Appeal Decision

Appeal Ref: APP/R5510/D/22/3311953

1 Dale Close, Pinner, Hillingdon, HA5 3UU

Proposed Elevations

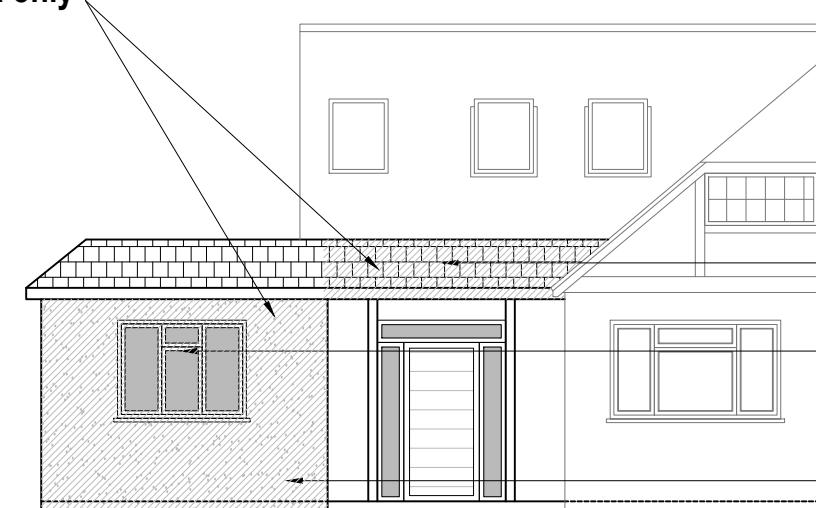
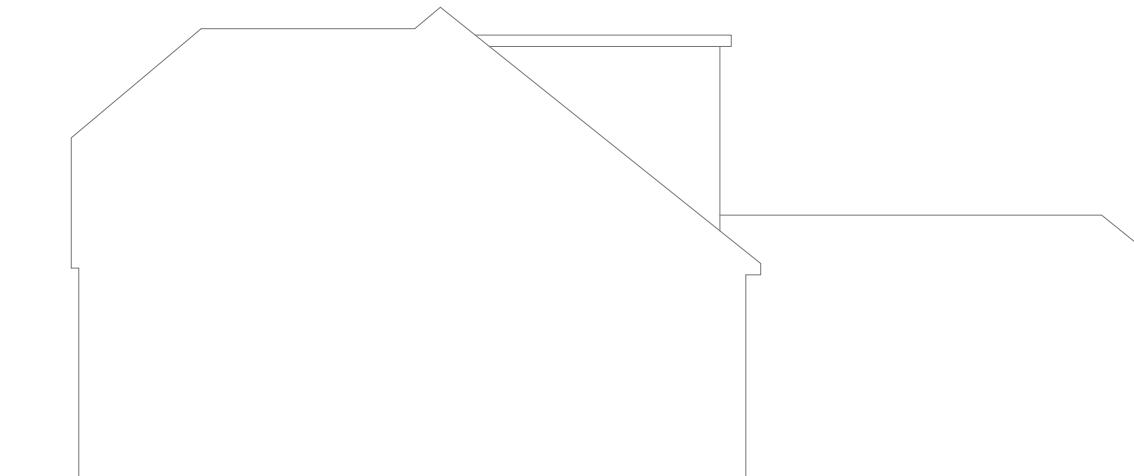
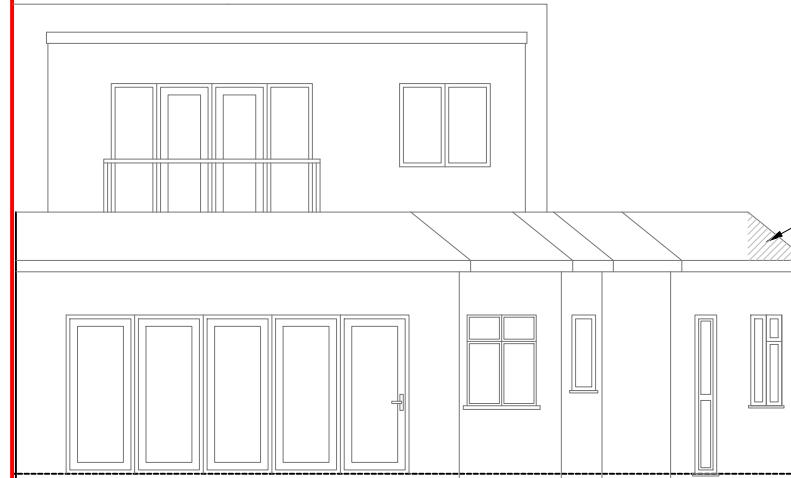
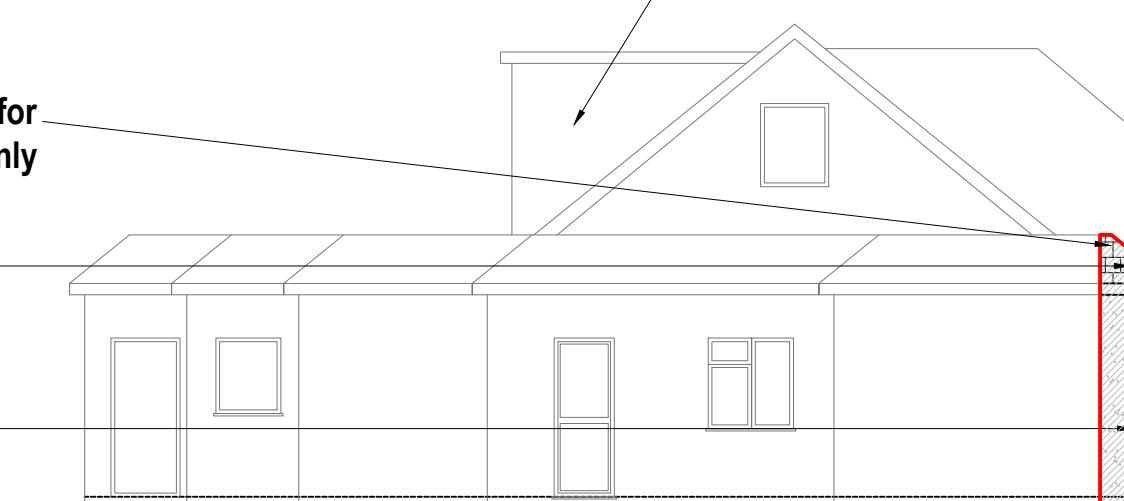
8. The proposed development would create an enlarged extension towards the front of the property with a roof canopy porch. When combined with the approved extension, I find that this would result in the creation of an awkward addition that would jar with and appear disproportionate to the appearance of the approved extension. It would result in an overall extension that would appear incongruous against and fail to appear subordinate to, the host dwelling.

9. The harm arising as a result of the above would be exacerbated as a result of the prominent location of the appeal property, whereby an awkward and disproportionate addition to the front of the dwelling would draw attention to itself as a widely visible incongruous feature.
